Landscape Architectural Statement of Response to the Pre-application Consultation

Project: Proposed Strategic Housing development (alterations to phase 1 residential and proposed phase 2 residential development) at the Frascati Centre, Frascati Road, Blackrock, Co. Dublin

Date: 24th August 2020

Re: Case Reference: ABP-306989-20 Proposed Development: Alterations to Phase 1 permission of 45 no. apartments of previous permitted Reg.Ref:D17A/0950 and ABP-300745-19 to provide a total of 105 no. apartments and associated site works.

Drawing file: Landscape Drawings / 19-524-PD-01_Landscape Master Plan & Planting Schedule.pdf

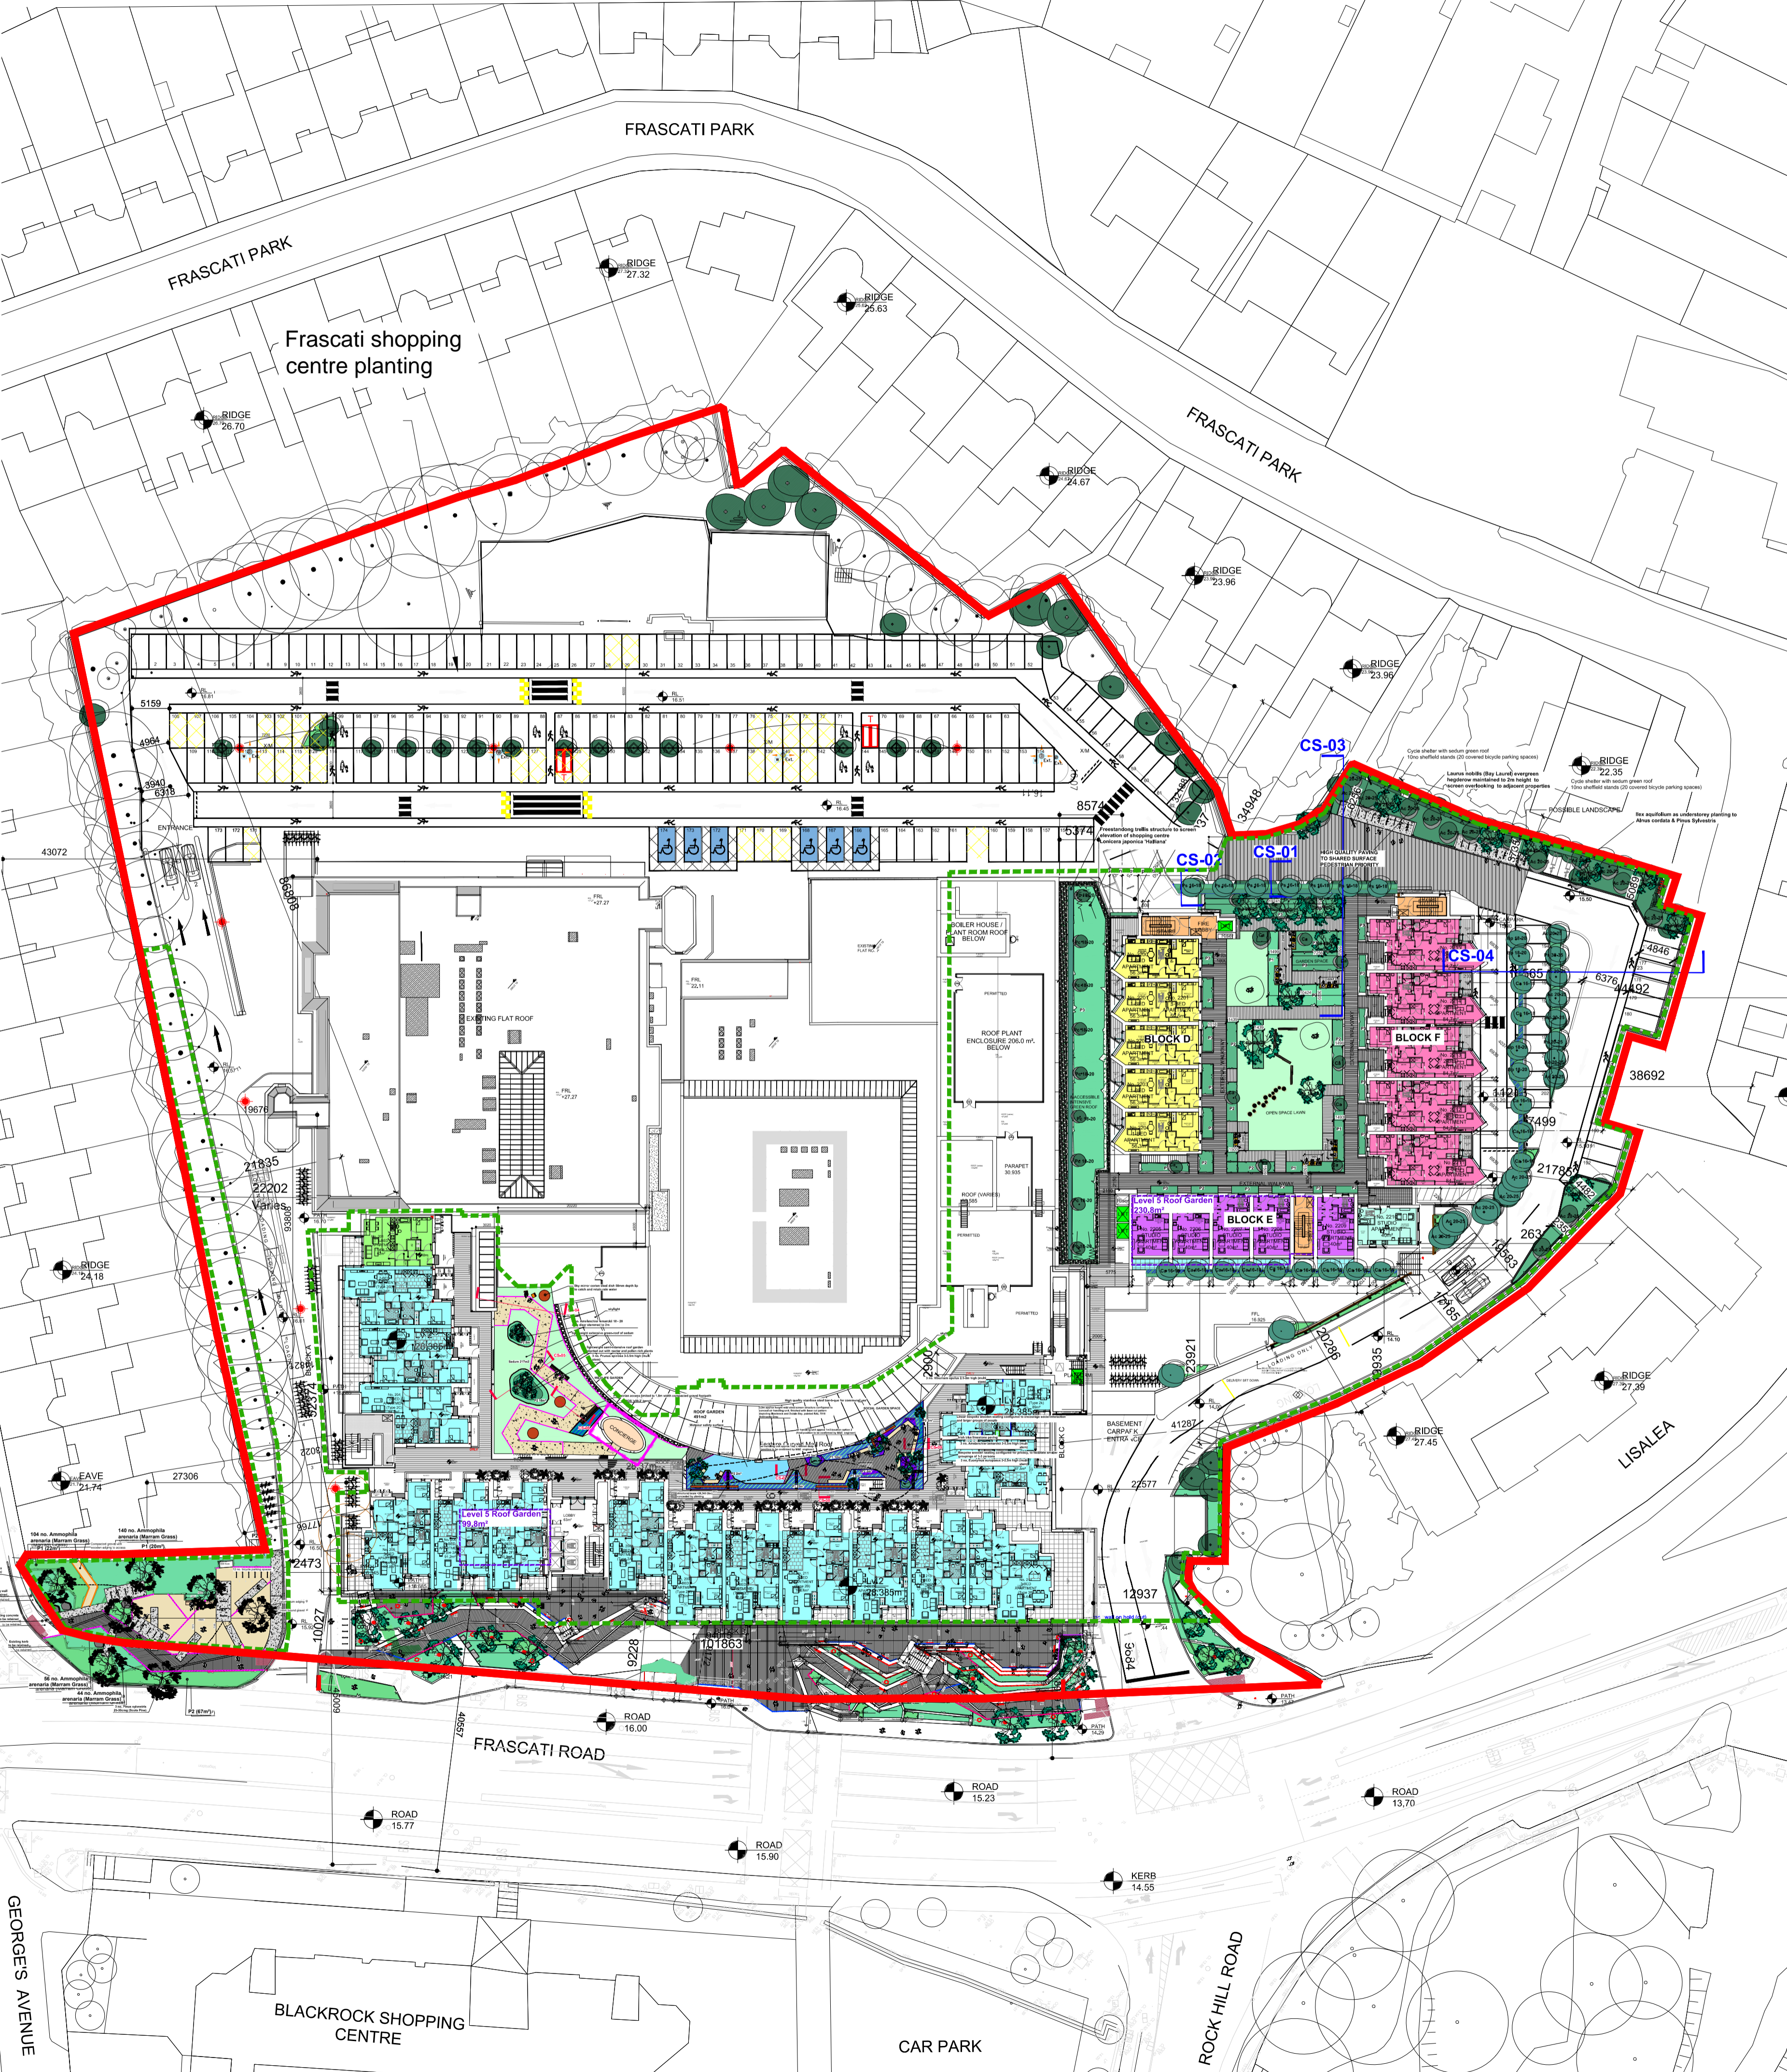
7(d) Topographical survey of the site and detailed cross sections to indicate existing and proposed ground levels across the site, proposed FFL's, road levels, open space levels, drainage infrastructure, landscaping, etc. relative to each other and relative to adjacent lands and structures including public roads.

It is not proposed to adjust existing ground levels. Pre-existing ground levels are to be retained except for three locations (highlighted by blue cloud on the below plan) where it is proposed to break out bitmac surfacing across a number of existing car parking spaces and access road surfacing to facilitate additional screen planting to mitigate the proposed development by way of visual impact and reduce surface water run-off. These areas of additional planting would be excavated to a depth of 400mm and backfilled with 300mm depth topsoil finished with 75mm depth bark mulch. Individual tree pits measuring 1m3 will be provide to each tree. Refer to landscape plan drawing number 19-524-PD-01 for further detail.

CONSTRUCTION SECTION CS-01- SECTION THROUGH WIDER PLANTERS & ROOF GARDEN / Scale 1:100

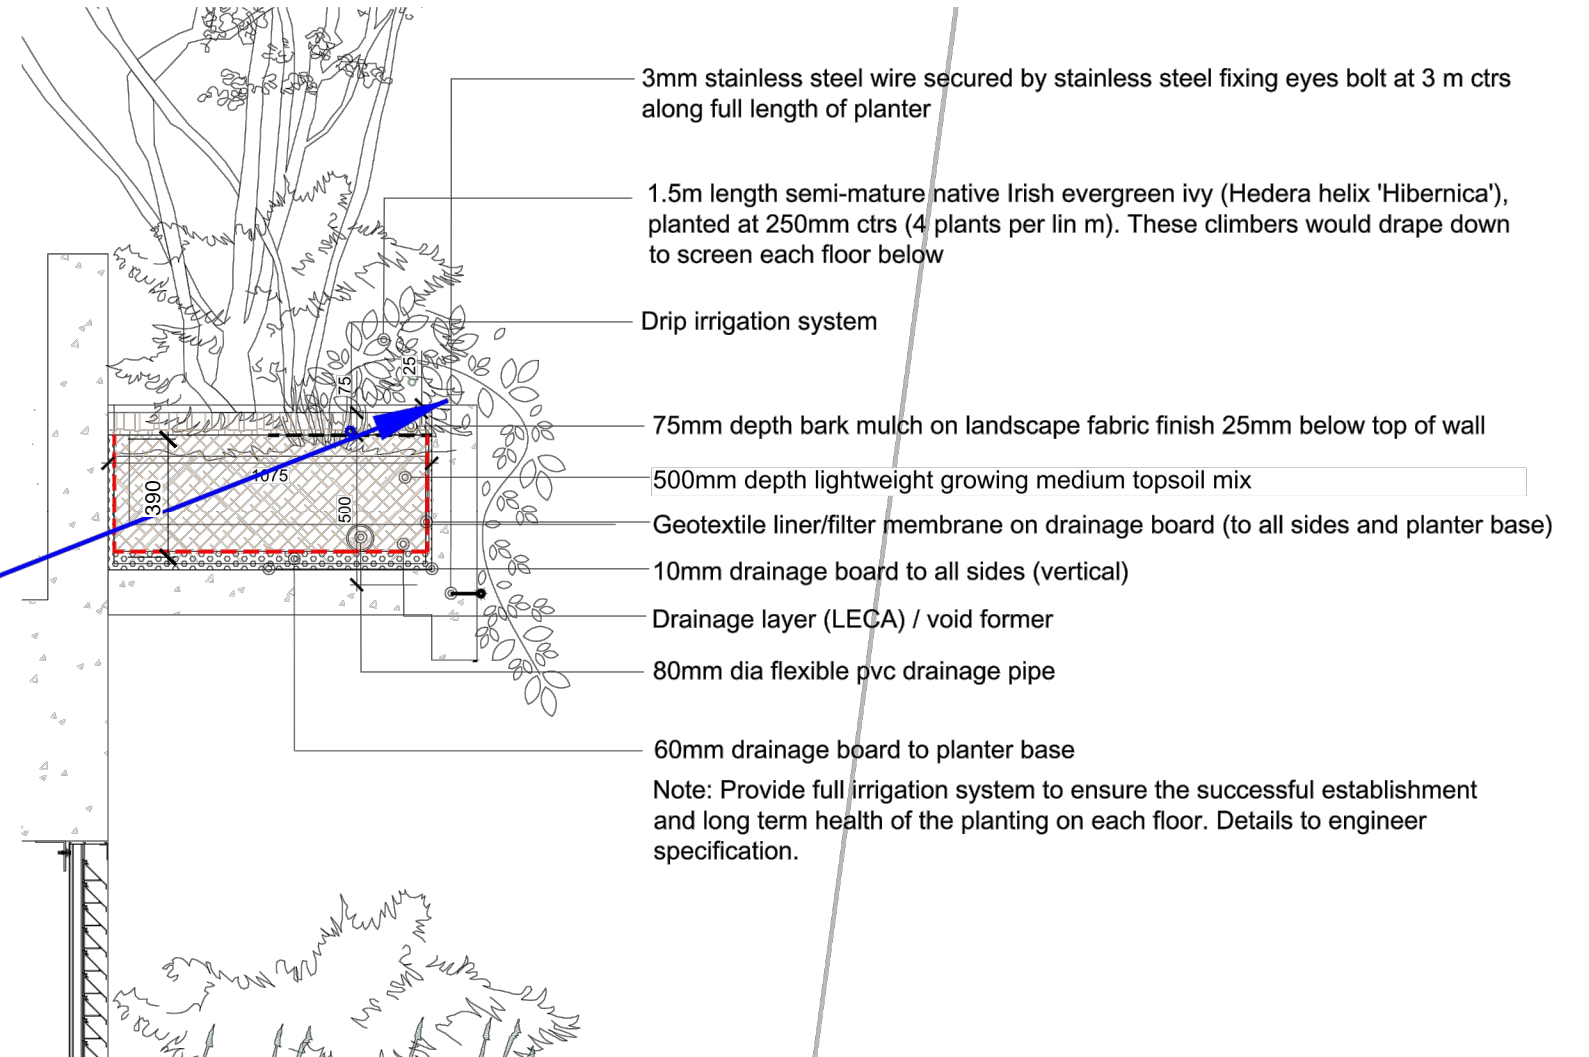
7(a) Detail of the landscaping of podium areas to include planting depths, irrigation method and maintenance regime (also ref below comment from Marc Campbell).

'The applicant's landscape design proposal is based on podium gardens and terraces. Although this is nothing new within dense urban development, its success lies in the detail of the infrastructure put in place to both establish and sustain these environments in a successful and sustainable manner. DLRCC Parks Department accept the principle of podium landscape design, but significantly more detail is required for an accurate assessment to be made on the proposal. There are concerns relating to the fundamental elements required to establish and support a thriving ecosystem; sufficient growing space, growing medium, irrigation, drainage, natural light and maintenance systems.'

Detail of the landscaping of podium areas to include planting depths, irrigation method and maintenance regime has been provided in the attached landscape plan drawings. Plan dimensions to all podium planters is provided on drawings 19-524-PD-01 and 19-524-PD-02. Further specific detail on topsoil depths provided to ensure the successful establishment and long term survival of trees, hedgerows and shrub/climbers is detailed in Construction Sections CS-01, CS-02, CS-03 and CS-04. A

minimum of approx. 600-800mm depth topsoil will be provided to all above podium trees, reducing to 300mm depth for ornamental shrub planting.

Enrich Intensive Roof Soil, a lightweight modified topsoil mix has been specified to all above podium planters and building elevation planters. This specially tailored soil mix is designed for use on roof gardens to facilitate trees, shrubbery and floral gardens detailed within podium planters. Enrich Intensive Roof Mix is Manufactured to the FLL Guidelines and BS 3882:2015. See Appendix A for Enrich Intensive Roof Mix data sheet. Provision of a 40/60mm drainage board across all intensive planters will facilitate free drainage to a series of outlet gullies provided across podium level and building elevation planters.

Drawing file: Landscape Drawings / 19-524-PD-10_Green Wall Elevation - 3 years post Completion.pdf

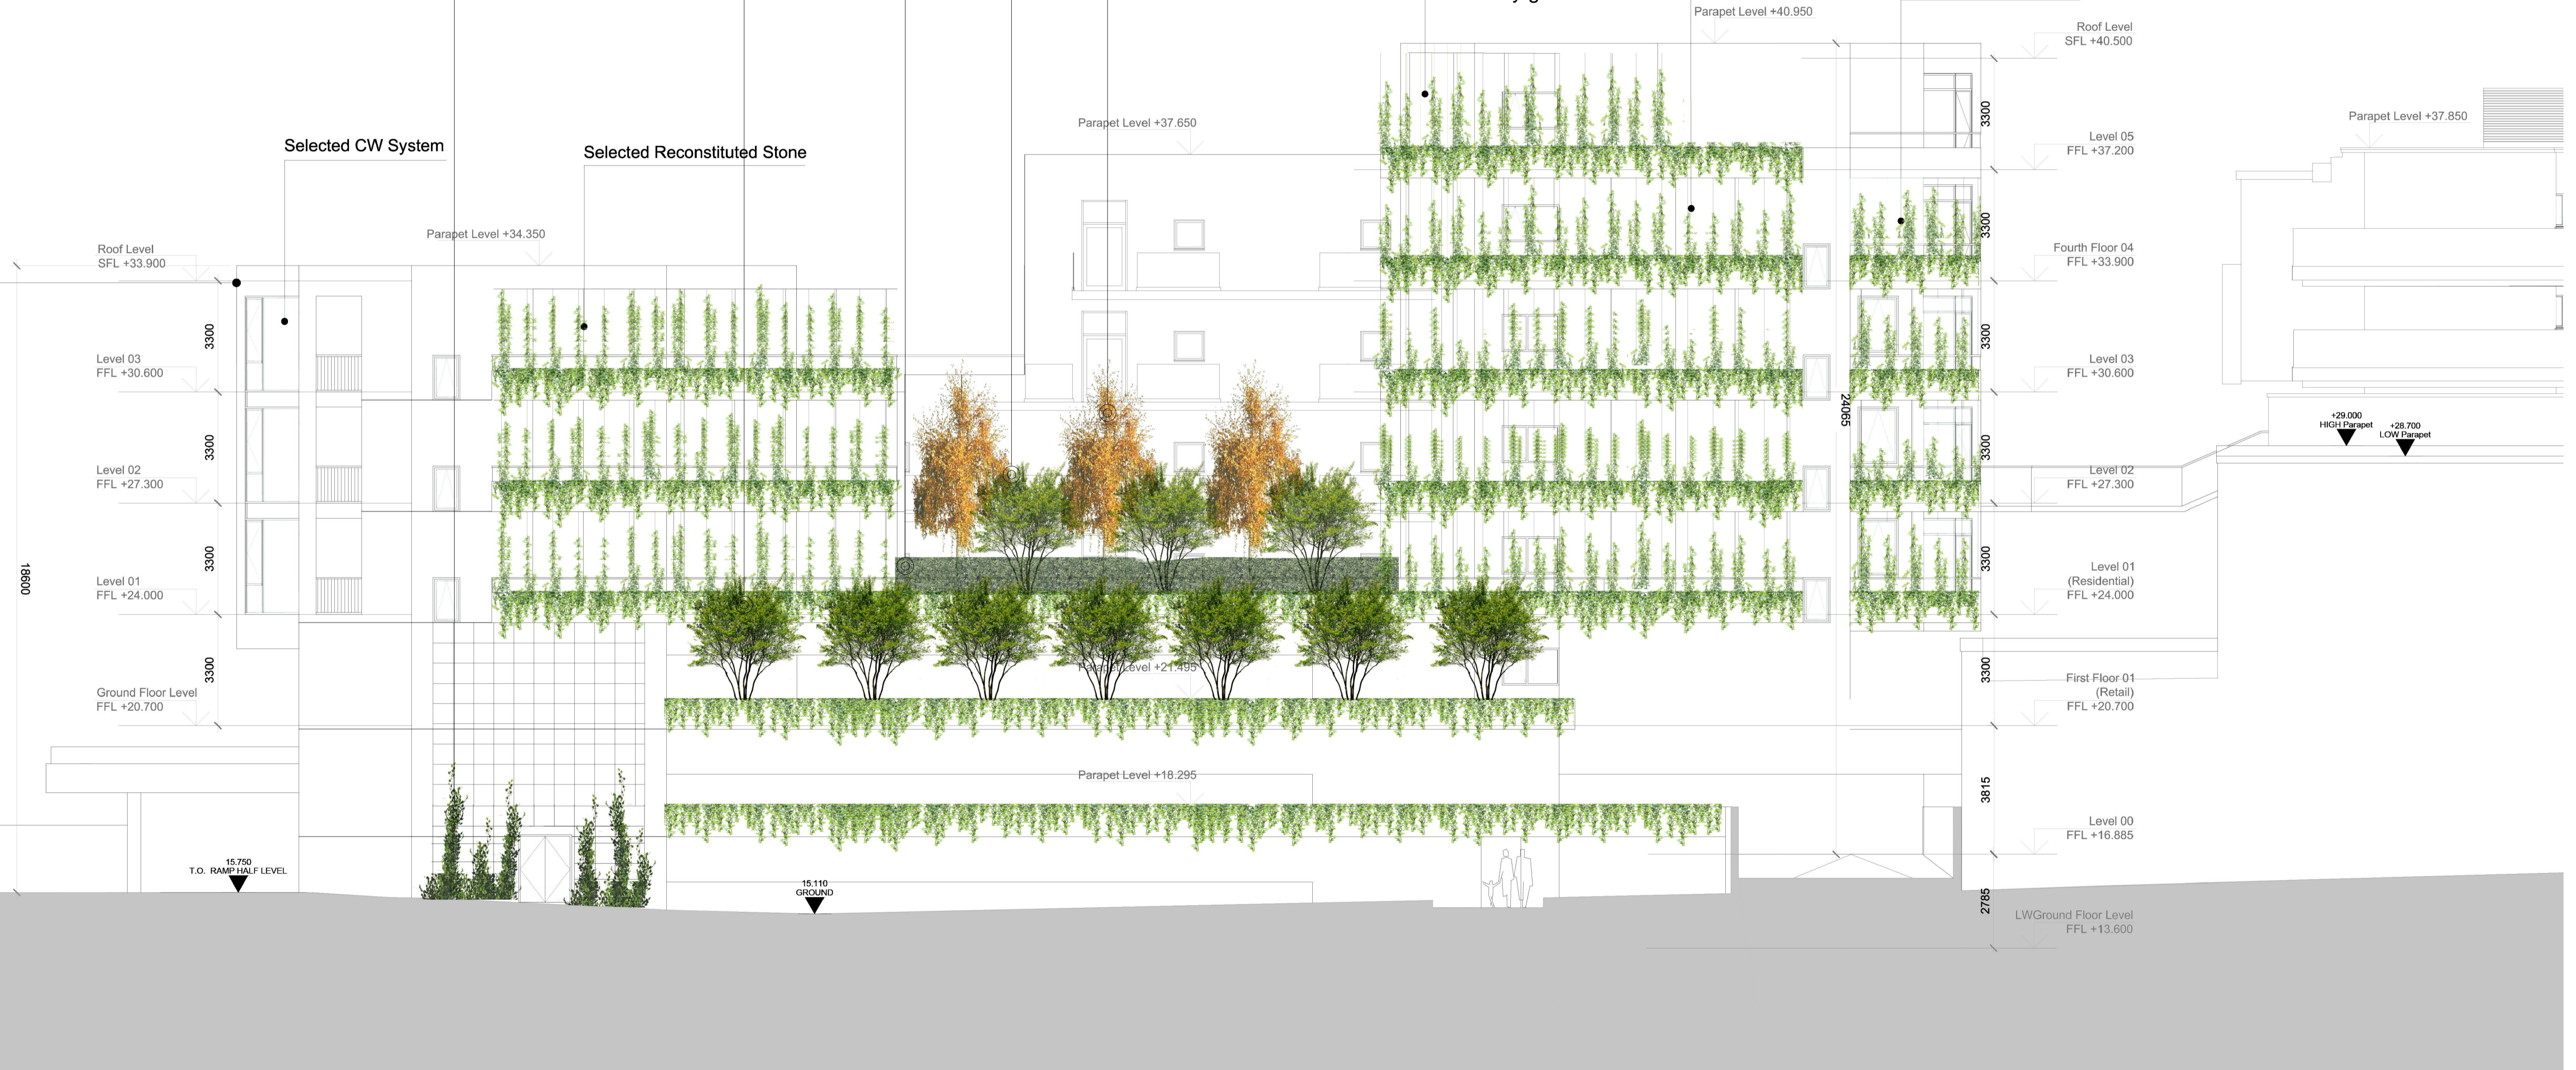
Illustrations of the green wall after completion, and after 1, 2, 3 years etc. should be included to demonstrate the length of time that will be needed before full growth will be achieved.

Refer to landscape drawing number 19-524-PD-08 for illustrations of the green wall on completion of the project after 3 years and finally after 6 years when the green wall vegetation will have reached maturity as represented in the above photo of East Point Business Park.
